Town & Country Planning Act 1990 (as amended)
Town & Country Planning (Tree Preservation) (England) Regulations 2012

Application No: BN/59/22/T
Site Address: Land South East Halliford Drive Barnham PO22 0FB
Description of works: 1 No. Poplar tree (T3) - remove 1 stem overhanging neighbouring property (26 Songthrush Lane) on eastern side of canopy. 1 No Poplar tree (T4) - reduce height by approx. 2-3m to leave approx. 12m. 1 No. Alder tree (T8) fell to ground level.

Thank you for your internet representation made on 22nd May 2022 which has been recorded as an objection with the comments as follows:

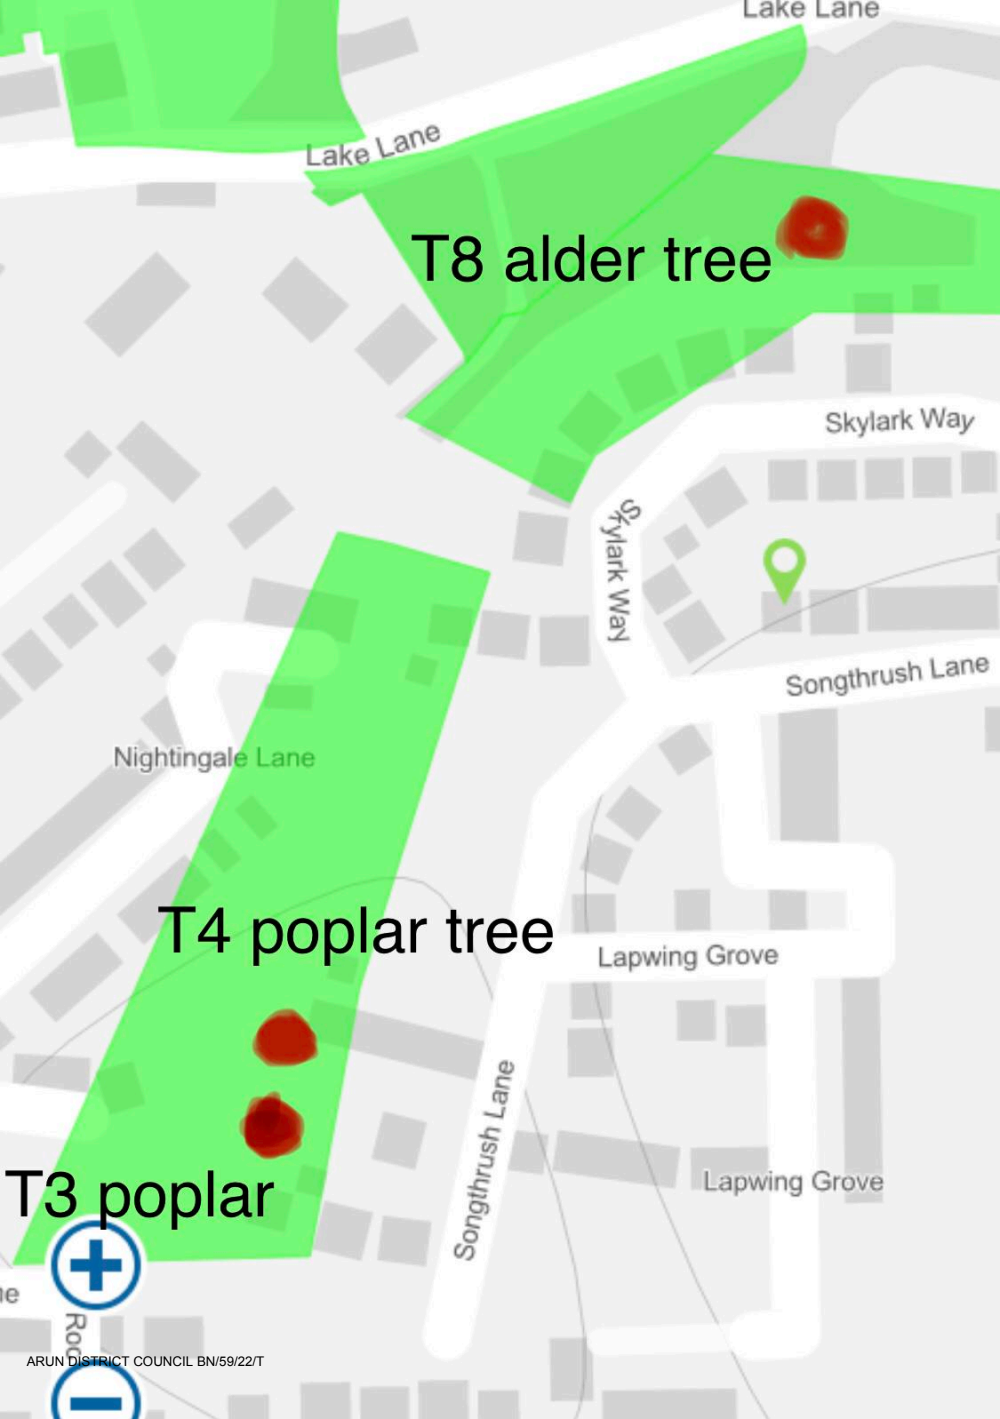
There also appears to be an anomaly regarding tree T8. In the sketch plan of 3rd May 2022 it is depicted as being to the North East of trees shown on TPO/BN/1/15. Researching further, in particular with respect to the Tree Constraint Plan (BN/15/11 - 25th May 2011), T08 in this position on the sketch plan appears to be a Quercus Robur (English Oak). Please would you provide clarification?
